From: Nicola Spencer
Sent: 01 June 2026 10:36
To: william maynard
Subject: RE: Planning application LU/120/26/HH 7 Norfolk Place Littlehampton
Attachments: Extracted pages from PACK 1.pdf

Thank you for your recent planning application. Unfortunately, there are a number of issues that need to be resolved:

Existing South Elevation

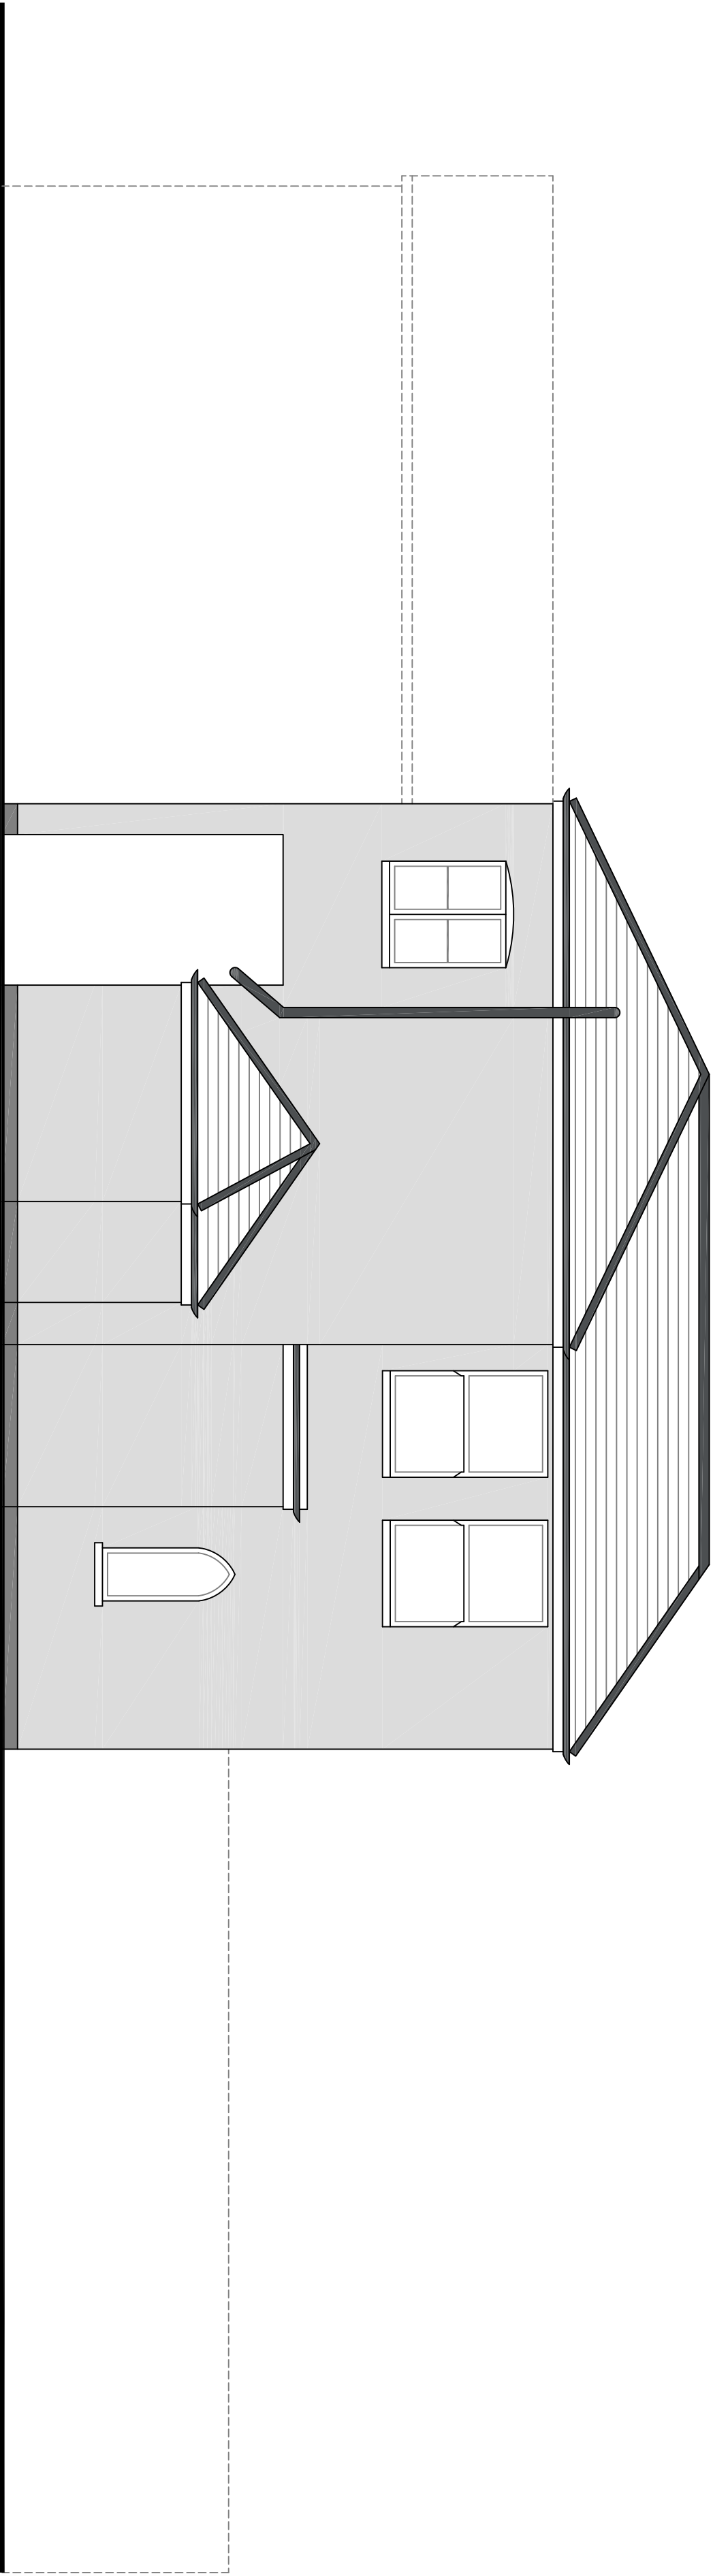
4. Block plan – a plan at the scale of 1:500 clearly indicating where the works have been carried out e.g. hatching the roof that has been replaced.
5. Elevations – please provide elevation plans at a scale of 1:50 or 1:100. Whilst your photographs are helpful, we need to be able to scale from the elevations. One set of plans will be acceptable if clearly labelled pre-existing and existing as the works have already been carried out.
